WEST SUSSEX COUNTY COUNCIL CONSULTATION

TO:	Arun District Council FAO: Harry Chalk
FROM:	Highways, WSCC
DATE:	18/02/2025
LOCATION:	Land to West of Crookthorn Byre, Brookpit Lane, Climping, BN17 5QU
SUBJECT:	CM/4/25/PL Erection of 1 No two storey dwelling (self build) (resubmission following CM/15/24/PL). This application affects the setting of listed buildings, is a Departure from the Development Plan and is in CIL Zone 5 and is CIL Liable as a new dwelling.
DATE OF SITE VISIT:	N/A
RECOMMENDATION:	Advice
S106 CONTRIBUTION TOTAL:	£N/A

SOUTH ELEVATION GARAGE AND CONTEXT

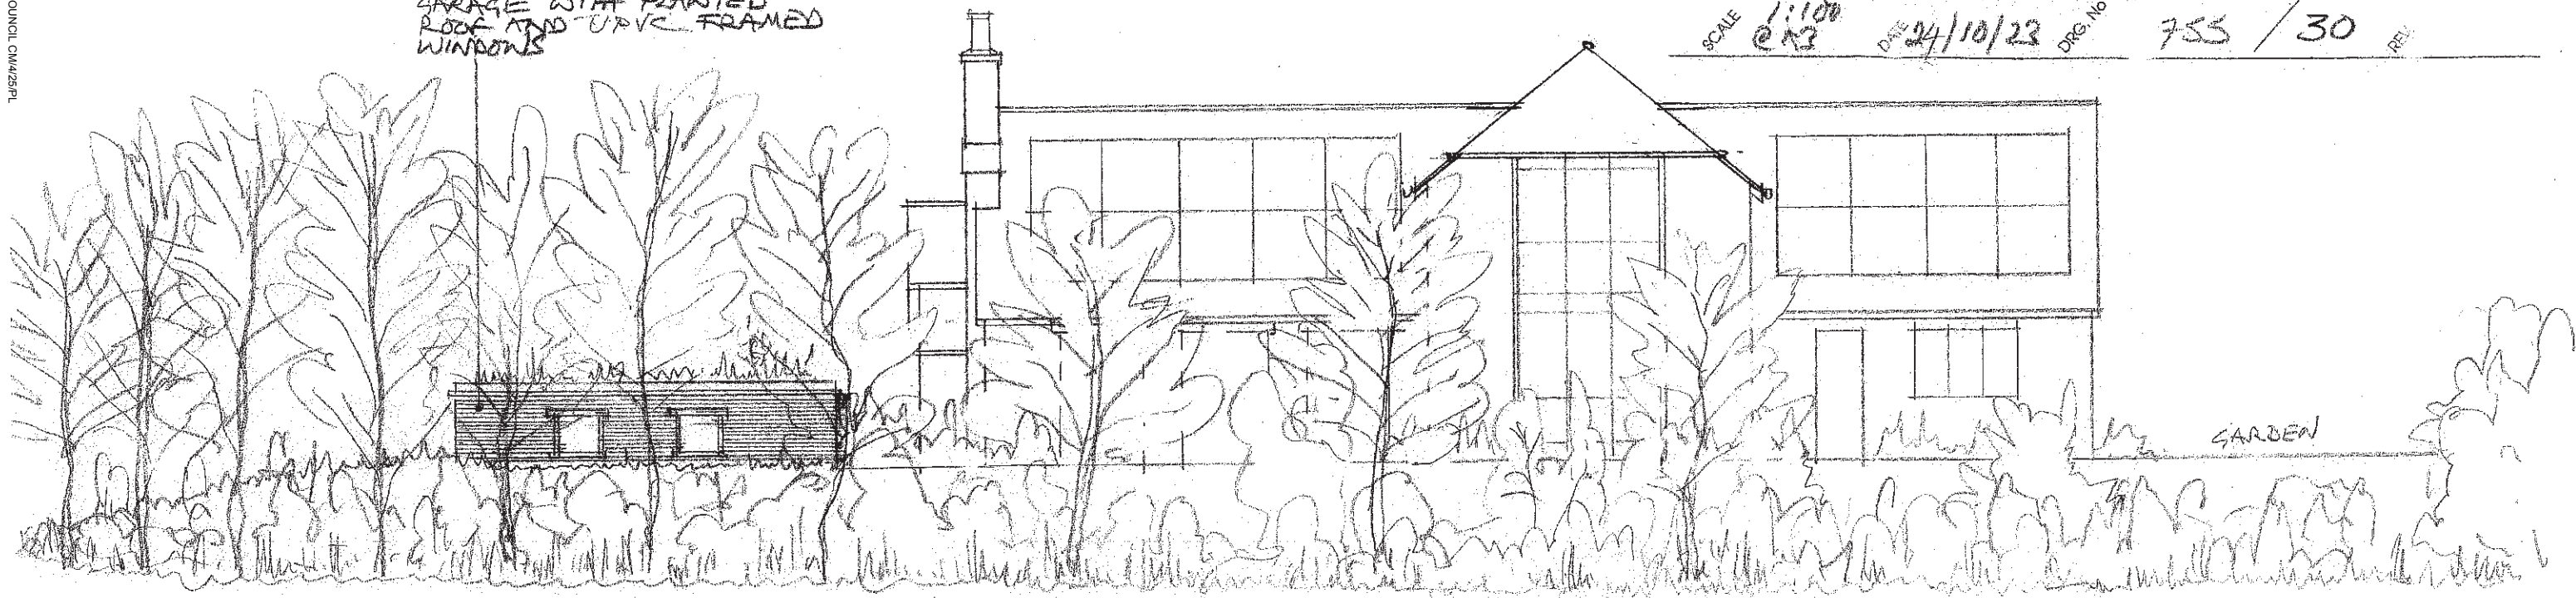
I would note that the proposed garage does not meet the minimum internal specifications for a double-bay garage of 6m x 6m as outlined in Manual for Streets (MfS). The LHA would advise that the garage should be enlarged to ensure modern sized cars and bicycles can be accommodated inside.

No details of secure cycle parking provision have been provided, and this should be demonstrated in accordance with Arun Parking Standards. As above, the LHA would be minded to accept the use of the garage for storage of cycles if it is enlarged to MfS specifications.
